# Lower Thames Crossing

## 5.4.4.11 Draft Agreed Statement of Common Ground between (1) National Highways and (2) Transport for London (Clean version)

**DATE: September 2023**  
**DEADLINE: 4**

Planning Inspectorate Scheme Ref: TR010032  
Application Document Ref: TR010032/APP/5.4.4.11

Drawing file: TR010032 / TR010032-005281-Additional Submission - Land Plan - v6 Deadline 5 - Sheet 45 - Visual Aide.pdf

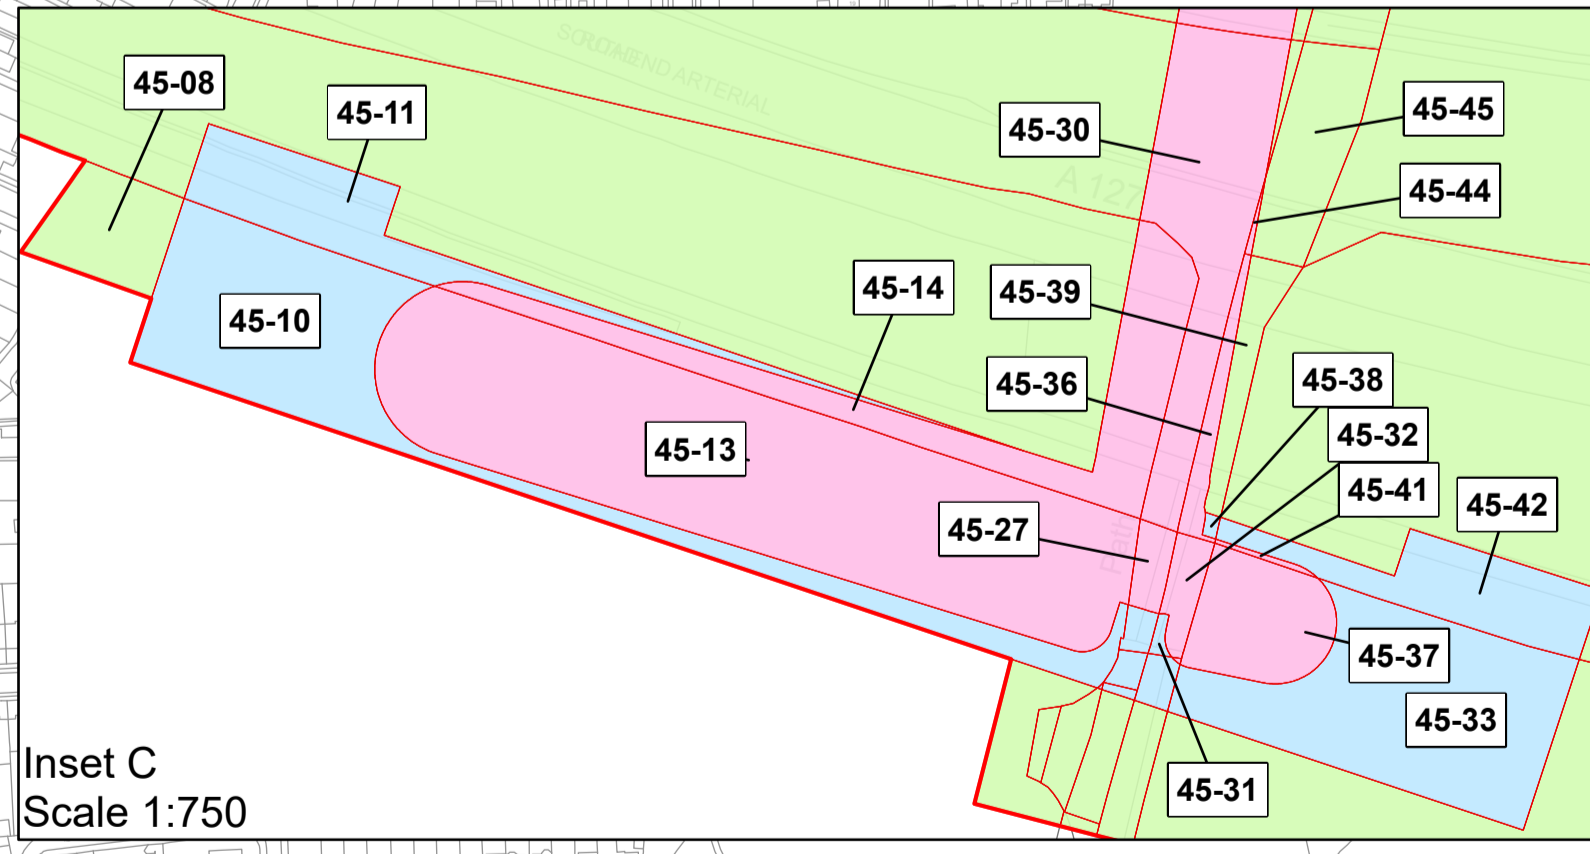
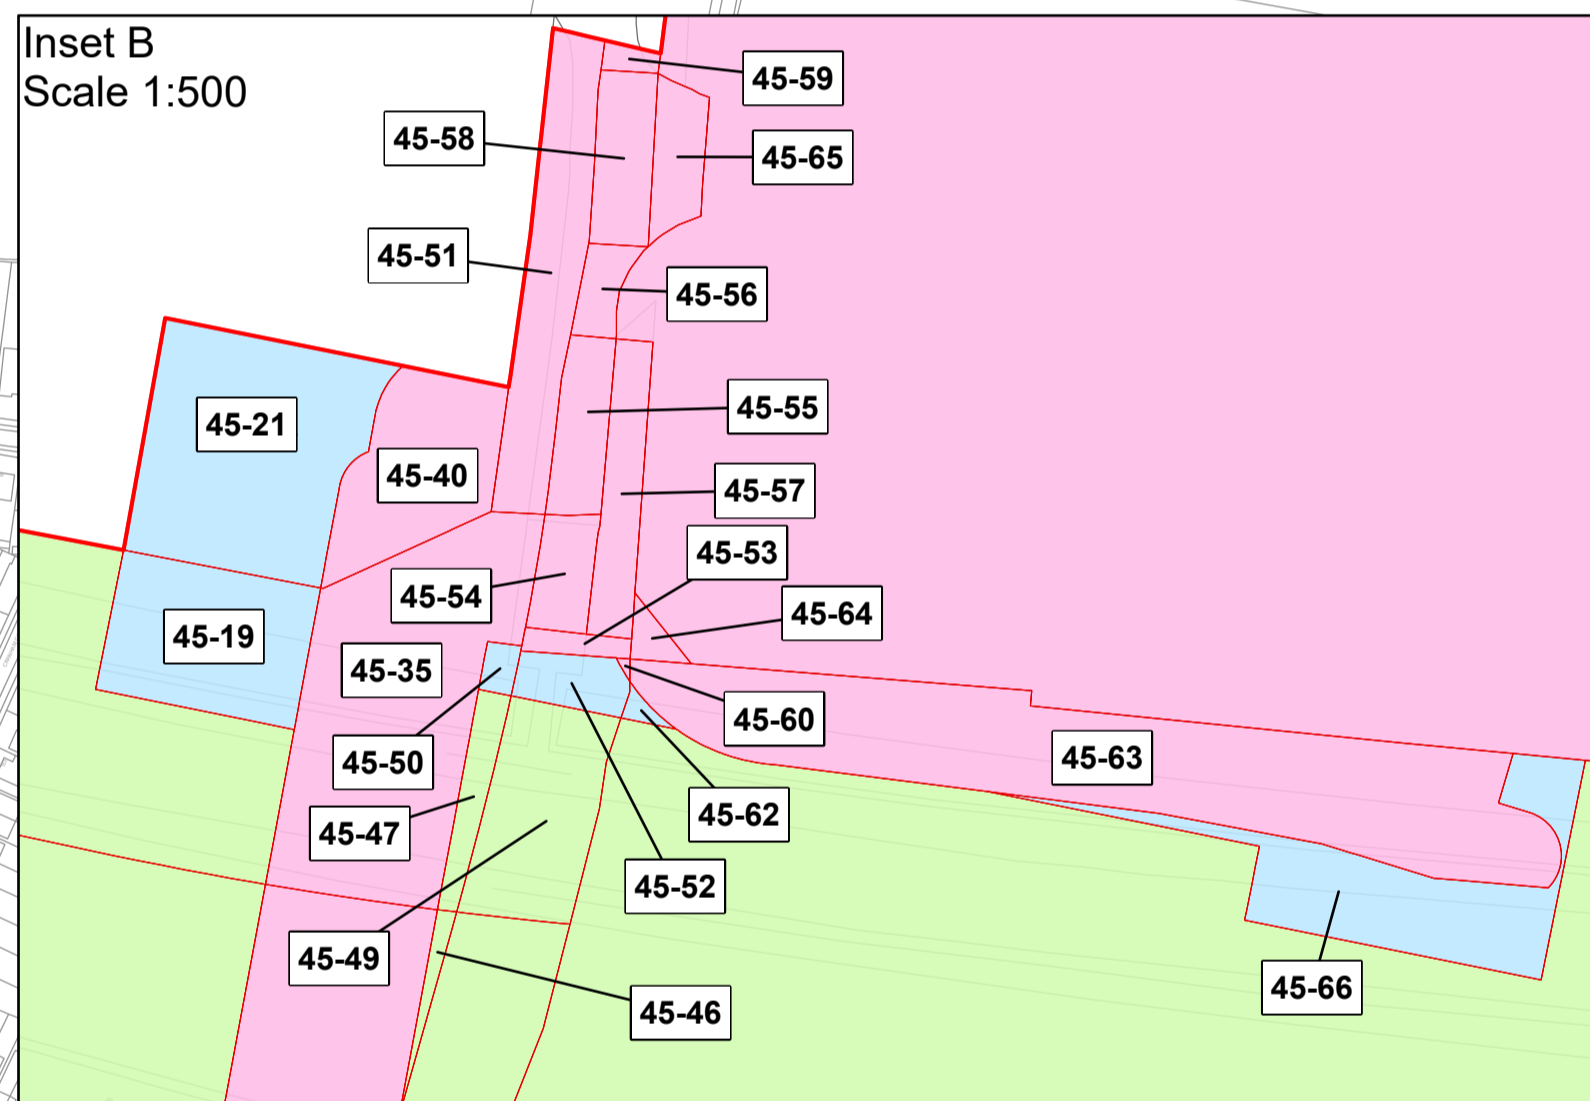
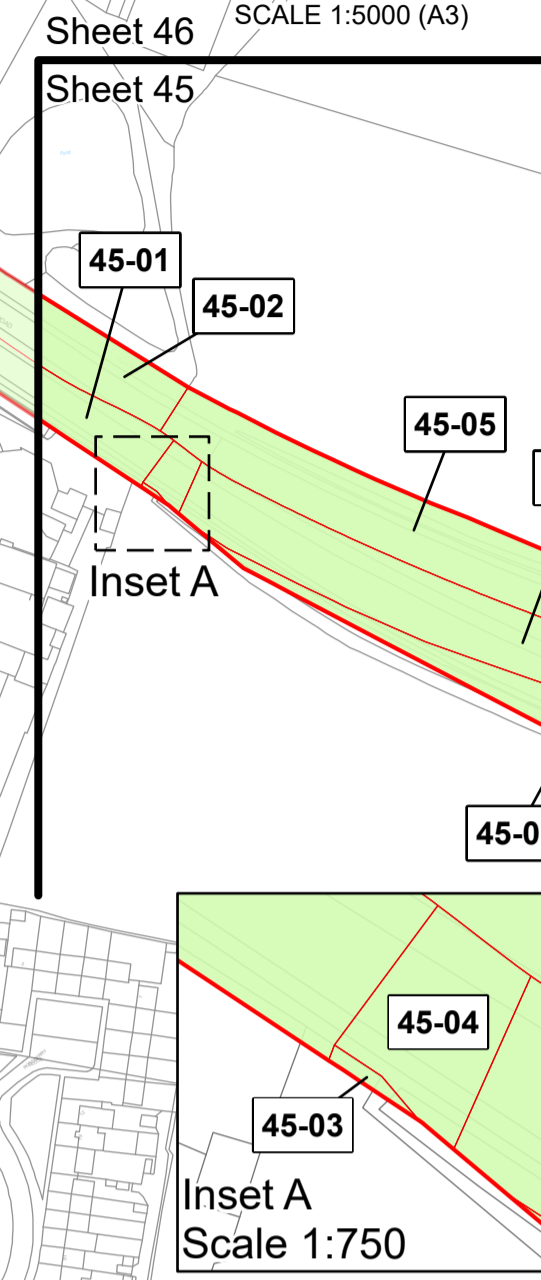
<b>Consultation and engagement</b>					
Adequacy of consultation	2.1.6	Transport for London is satisfied with the adequacy of consultation undertaken to date on the Project.	Noted.	N/A	Matter Agreed
<b>Land and compulsory acquisition</b>					
Land acquisition	2.1.7  RRE	Transport for London owns the freehold of certain parcels of land within the DCO application boundary around J29 of the M25 and relating to the A127.	The land use to the west of junction 29 has been amended to address these concerns and the majority of Transport for London's titles are now temporary use. There remain some areas where the Project requires temporary possession of land with the permanent acquisition of new rights for	Sheets 45 & 46 of the Land Plans <a href="#">[REP1-011]</a>	Matter Under Discussion

Topic	Item No.	Transport for London Comment	The Applicant's Response	Application Document Reference	Status
Permanent vs temporary acquisition		<p>The Land Plans from the previous application documents shared with Transport for London (October 2020) showed most of the land west of the roundabout within the order limits and the TLRN as it passes the roundabout as permanent acquisition. This would suggest that National Highways intends to take on responsibility for this part of the A127. However, the draft DCO that was submitted shows that National Highways are not intending to reclassify any part of the main carriageway of the A127. Permanent acquisition is therefore not required and the powers sought should be for temporary possession only at most but even those powers should be limited.</p> <p>Where the Applicant considers it needs to acquire Transport for London highway land or rights over such land to deliver the Project, Transport for London requires that such land over which Transport for London will remain highway authority should be returned to Transport for London's ownership at no cost following completion of the works. Transport for London raised this matter in its relevant representation where it requested an amendment to the draft</p>	<p>the diversion of utilities. Permanent acquisition of land is also required for a small section of route alignment and for the construction of the new walking, cycling and horse riding (WCH) bridge structure to the west of junction 29. It is agreed that the Applicant and Transport for London will progress discussions to return any permanently acquired land to Transport for London post construction, including the proposed WCH structure which Transport for London shall be responsible for maintaining.</p> <p>These issues were discussed at a meeting on 17 December 2021 (with subsequent communications between the Applicant and Transport for London Land &amp; Property specialists) and the requirements for permanent acquisition of rights were explained and accepted. At the 2022 Local Refinement Consultation, Transport for London reported that the latest acquisition plans provided by the Applicant address many of the concerns previously raised.</p> <p>Details of the land required for the WCH bridge were discussed at a meeting on 20 March 2023 with land and property specialists and legal representatives from Transport for London and the Applicant present. A draft side agreement between the Applicant and Transport for London is currently being discussed which will include details of the mechanism for transfer of land between the Applicant and Transport for London and the land requirements. As noted by TfL, the</p>

Topic	Item No.	Transport for London Comment	The Applicant's Response	Application Document Reference	Status
		<p>DCO, for this provision, but following discussions is now willing to consider its requirements on these matters being included in a side agreement with the Applicant.</p> <p>Transport for London understands that the Applicant will be submitting draft protective provisions for the protection of local highway authorities at Deadline 4 which may cover transfer of land. Transport for London will update its position on this issue following review of these protective provisions.</p>	<p>Parties are in discussion in relation to the proposed side agreement in an attempt to address issues raised by TfL.</p> <p>At a meeting on 12 September 2023, further discussions were held including an update on the land required for the bridge and its maintenance, the proposed side agreement between the two parties, powers for utility maintenance and, as TfL notes, draft protective provisions proposed for Deadline 4.</p> <p>It is agreed that the above-mentioned discussions on the final ownership and potential return of acquired land will occur post-DCO consent.</p>
